Re: The Peaks by Markana- Phase 1- Buildings 1 and 2
6700 Modesto Ave NE
Request for Certificate of Occupancy
Transportation Development Final Inspection
Plan Approval Date 10-28-21 (C18D088)
Certification dated 2-2-24

Based upon the information provided in your submittal received 3-1-2, Transportation Development cannot approve the release of Certificate of Occupancy for the above referenced project until the following items are addressed.

| C-101 | | CONCEPT GRADING PLAN | |

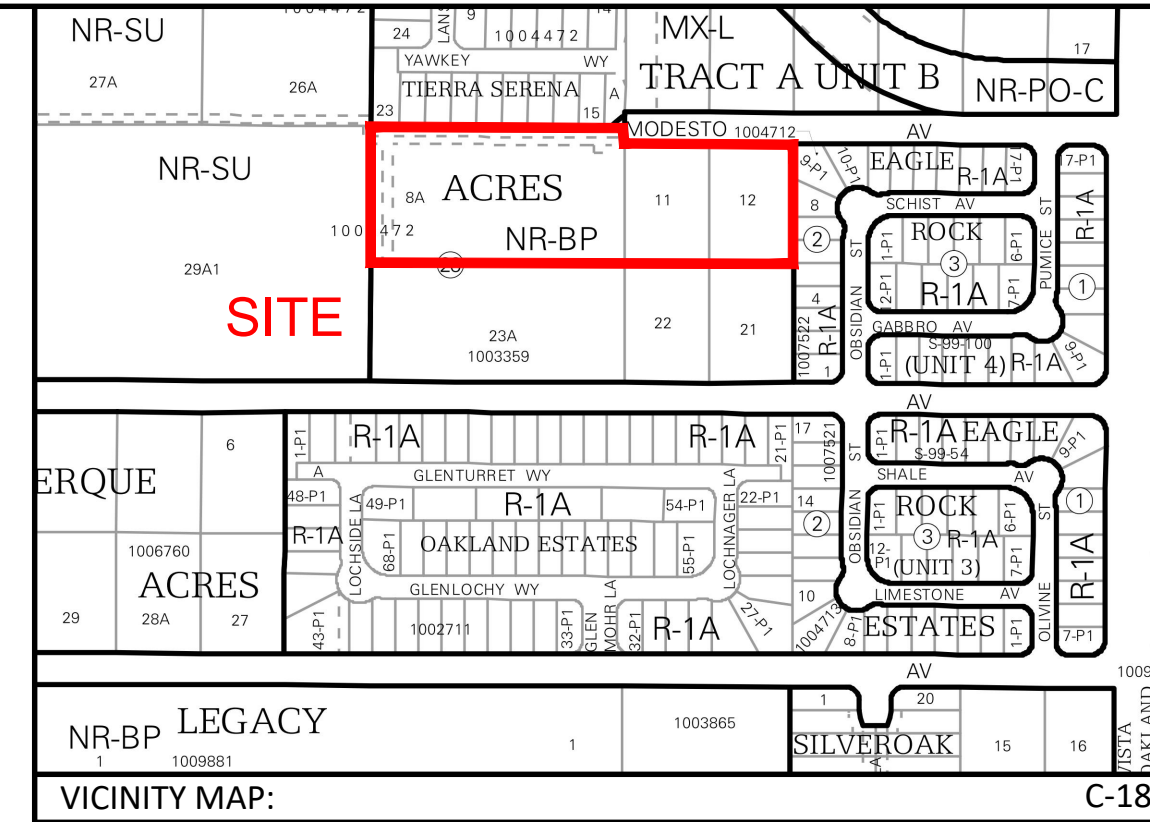
1. The ramp slope in the accessible path from the ROW was an average of 10.2%. The maximum allowable is 8.3% (12:1).
2. The pedestrian path pavement markings from building 1 to building 2 were not built.

5. The plan was not as-built. Include the ramp and hatched pavement markings near the dog park with your next submittal. The expectation is that the plan submitted with the Certification is an as-built and reflects what is present at the site.
